From: Kathryn Welch
Sent: 19 May 2026 16:25
To: Planning Scanning
Subject: FW: Y/18/26/PL

From: Kathryn Welch
Sent: 19 May 2026 13:36
To: 'Kate Holland' [Redacted]
Subject: RE: Y/18/26/PL
Importance: High

From: Kathryn Welch <Kathryn.Welch@arun.gov.uk>
Sent: 30 April 2026 13:24
To: Kate Holland [REDACTED]
Subject: Y/18/26/PL

I'd like to introduce myself; I am the Planning Officer dealing with planning application Y/18/26/PL. I have taken a brief initial look through the submitted application documents and wanted to raise a couple of early points for clarification.

Figure 2. Planting Plan of the proposed development (Drawing No. GLS_050_132_1500) (GreenLandscape, 2026)

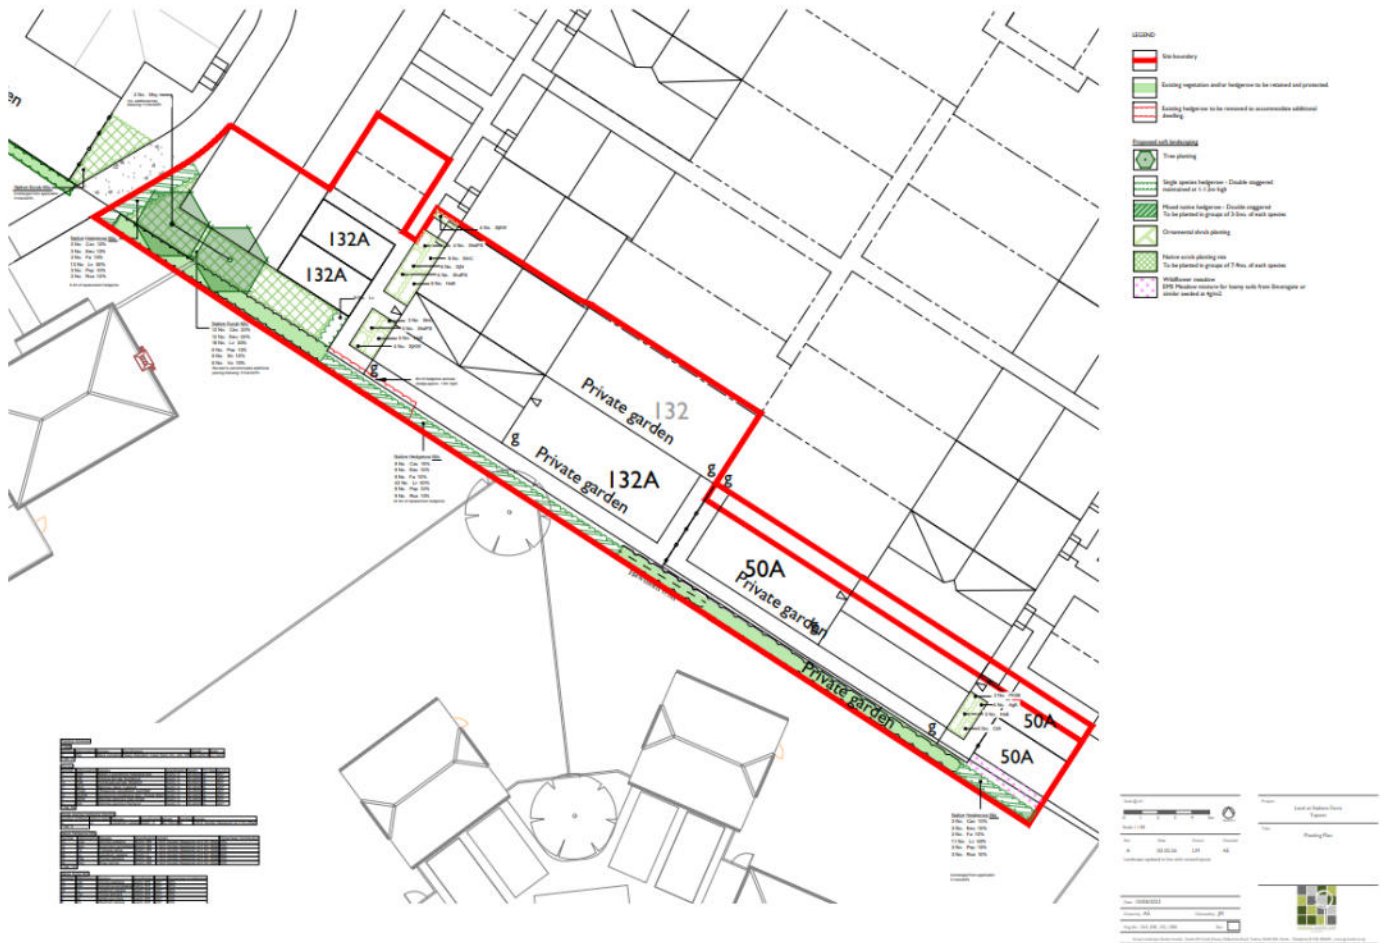
Just another issue that has been brought to my attention: the area highlighted in yellow now has a footpath crossing it. Your proposed layout, specifically the BNG and landscaping, may conflict with this crossing.
